CITY OF ALBUQUERQUE

Re: Patio Addition
5231 San Mateo Blvd NE
Traffic Circulation Layout
Engineer's/Architect's Stamp 06-12-18 (F17D073A)

**TRAFFIC CIRCULATION LAYOUT**

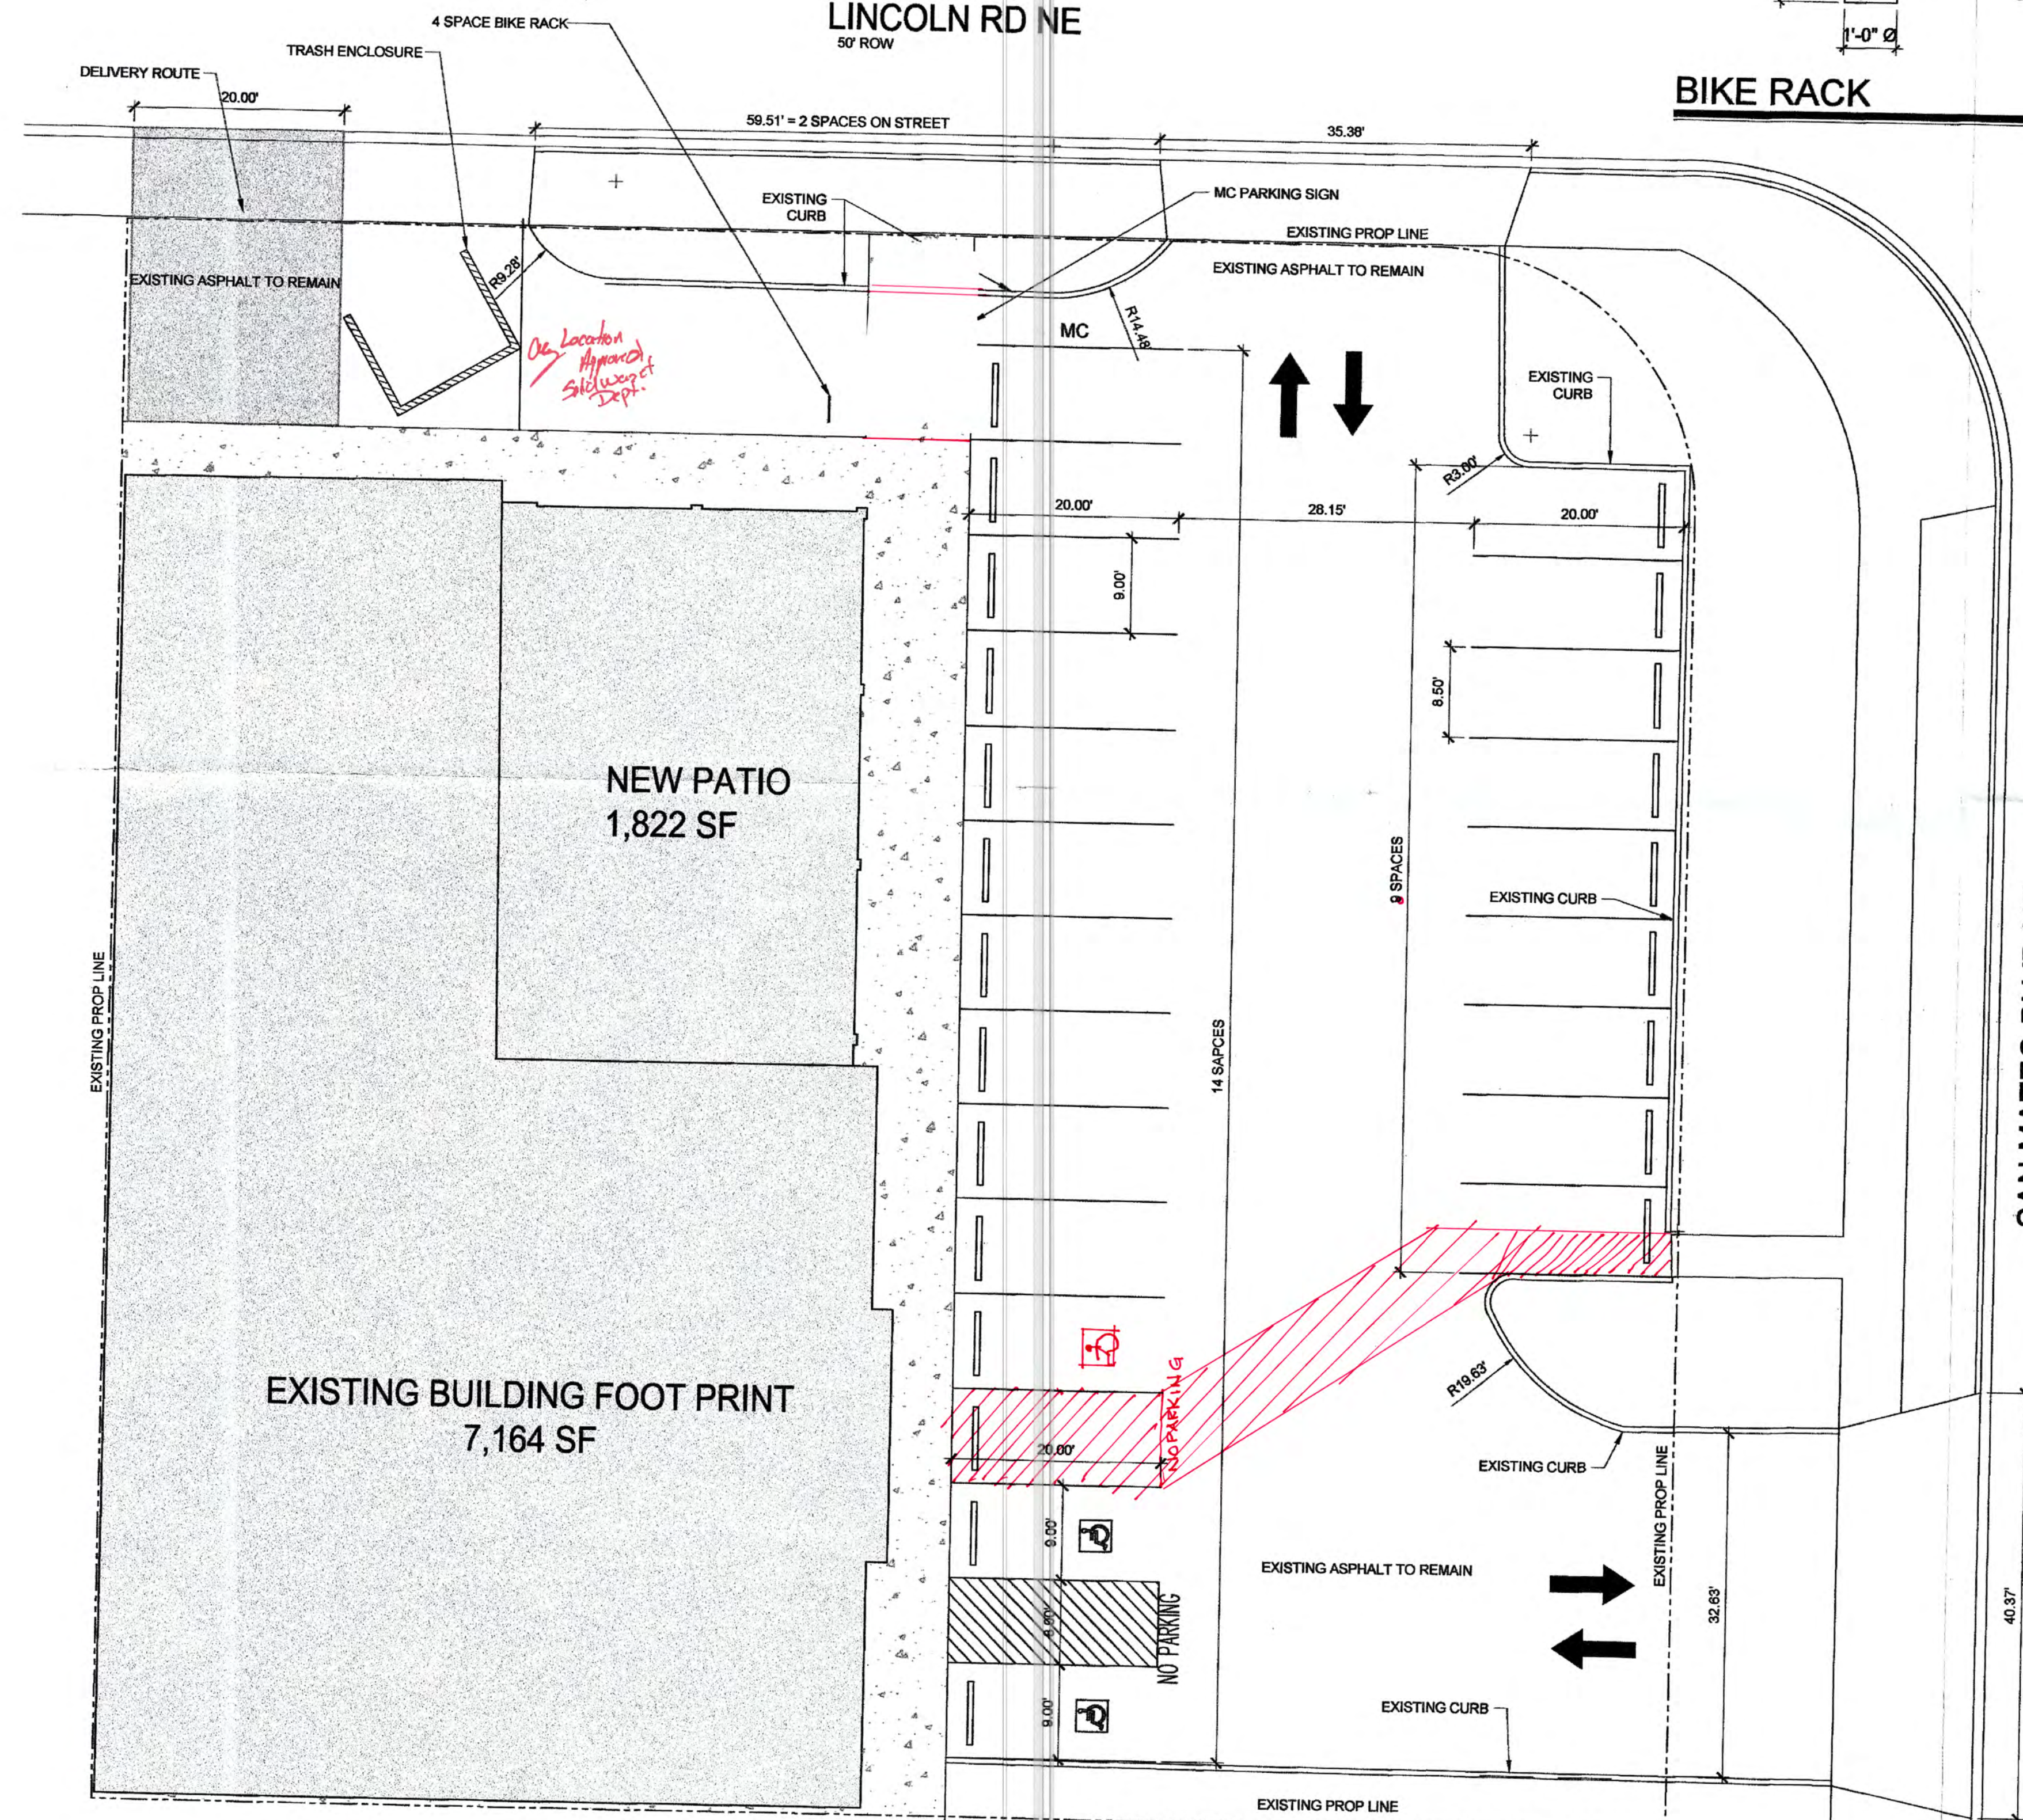
1. Please review and revise plan to provide all information listed on the Traffic Circulation Layout checklist.
2. Please show a vicinity map showing the location of the development in relation to streets and well known landmarks.

3. List the number of bicycle parking spaces required by the IDO.
4. Please revise parking to meet IDO standards.
5. Identify the right of way width, medians, curb cuts, driveways and street widths on Lincoln Rd NE & San Mateo Blvd NE

6. The handicap accessible spaces must include an access aisle. Van accessible aisles should be 8ft wide; all others should be 5ft wide.
7. List radii for all curves shown; for passenger vehicles, the minimum end island radius for passenger vehicles is 15 ft. Radius for delivery trucks, fire trucks, etc. is 25 ft. or larger.

8. Design delivery vehicle route needs to be shown.
9. Service vehicle and/or refuse vehicle maneuvering must be contained on-site; provide a copy of refuse approval.

10. Vehicles are not allowed to back out onto public right of way. Please relocate the single parking stall next to the refuse container location.
11. It is not apparent what type of pavement surface is being proposed. A hard driving surface will be required as part of this proposed project for parking area and drive aisles.
